Development Control
Ribbles Valley Borough Council

Your ref: 24.0667
Our ref: D3.24.0667
Date: 27th November 2024

Address: Ground floor Unit 5b Abbey Works King Street Whalley

Proposal: Regularisation of unauthorised addition of mezzanine floor and creation of bar/cafe upstairs

Location Plan
Site Address: Salvage House, Unit 5b, Abbey Works, King Street, Whalley, BB7 9SP

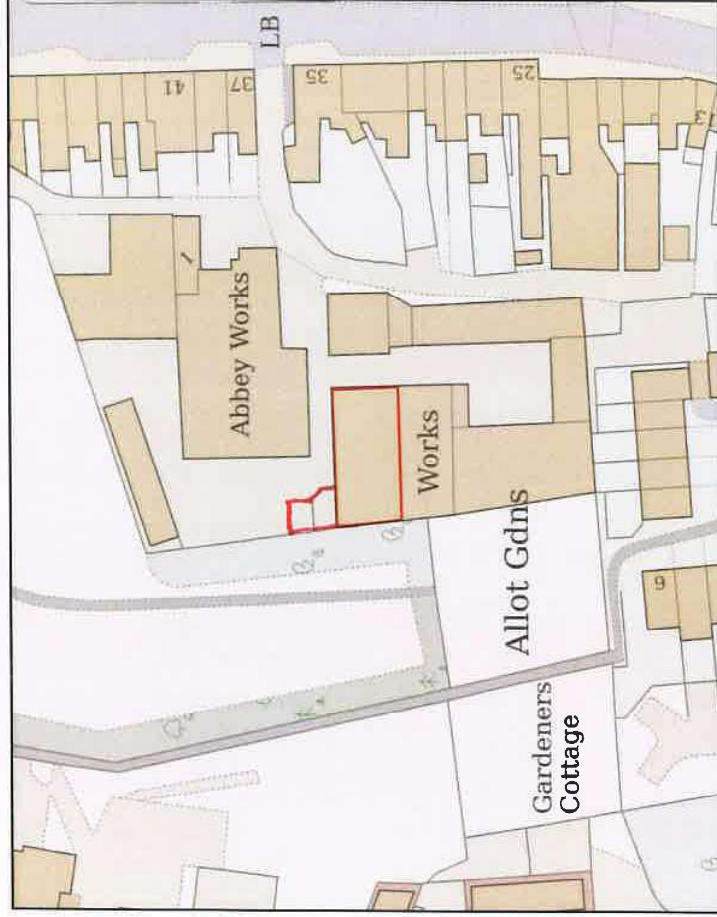
We would request that the access up to King Street and the car parking associated with the building is included in the red edge.
